Hall Street Mixed Use Development, Bondi

Waverley Council Development Application Addendum Design Report December 2008

Development Application Rev A
Design Report
S10788 December 2008

Level 07 Residential

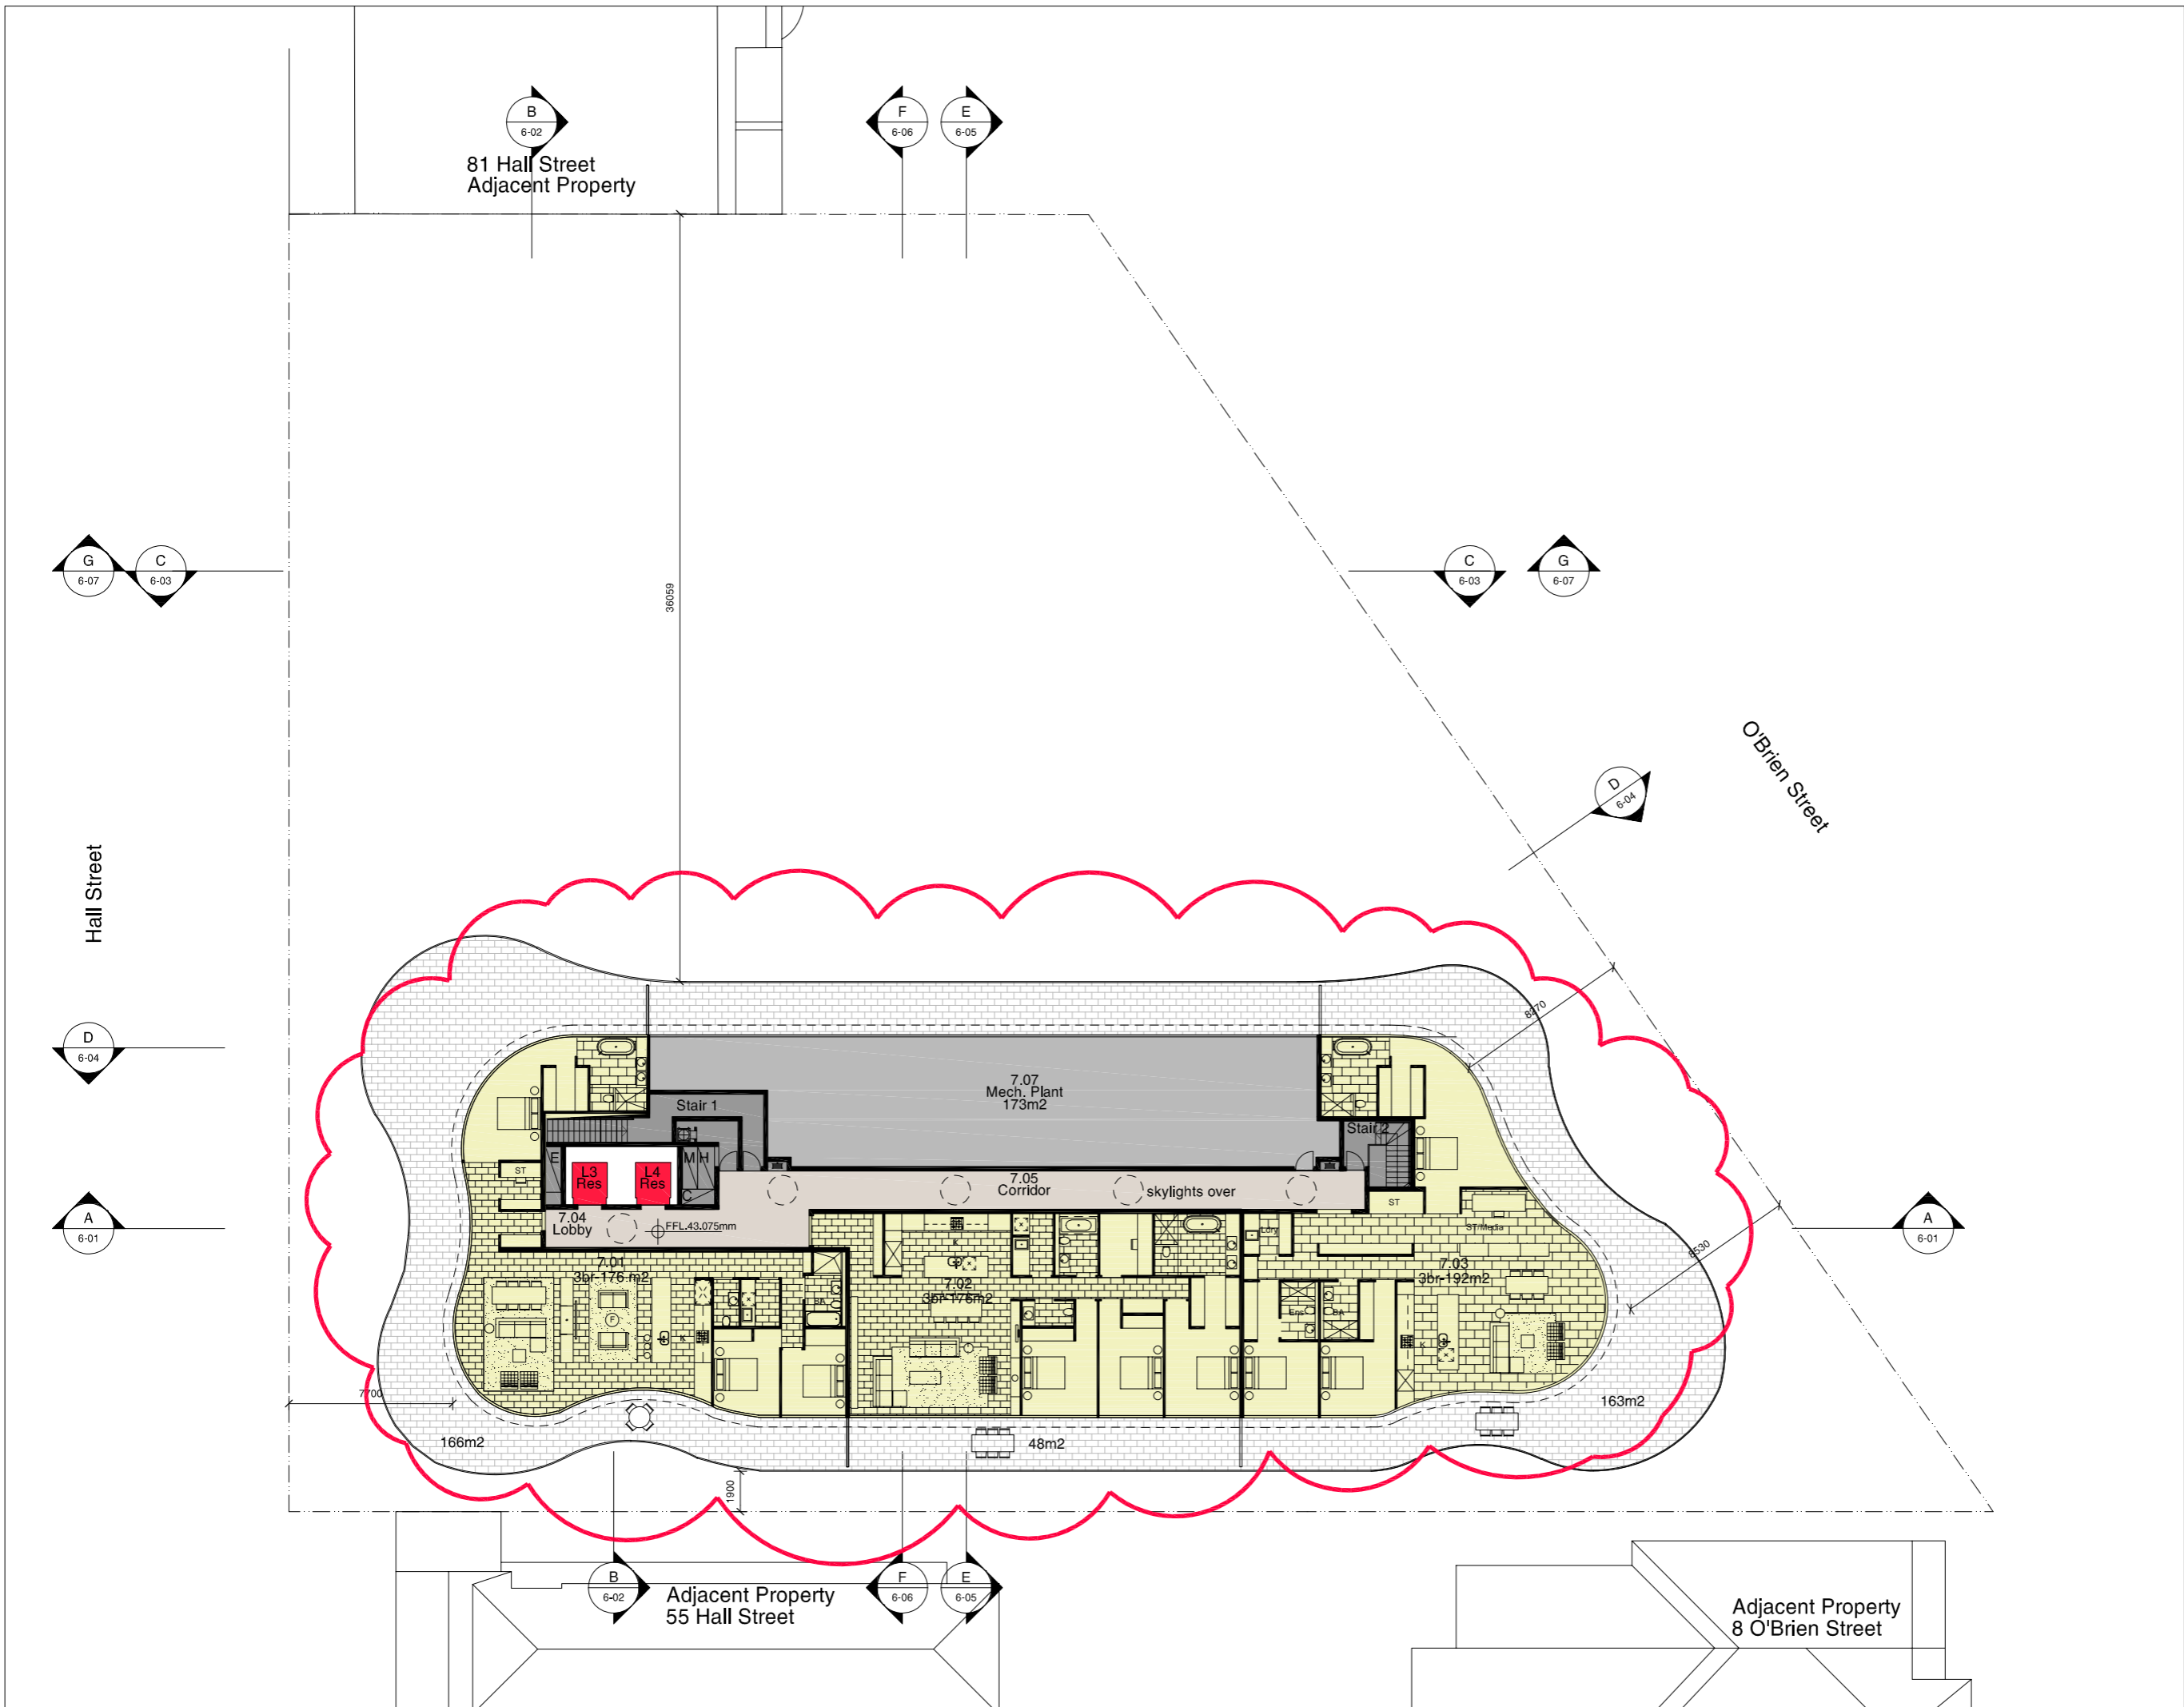
Level 7 has been remodelled setting back the curves at both street frontages to reduce visibility from the street.

Level 7 has been remodelled setting back the curves at both street frontages increasing the sky plane when viewed from street level.

Level 7 has been remodelled setting back the curves at both street frontages providing only very limited sightlines where it is visible from the street.
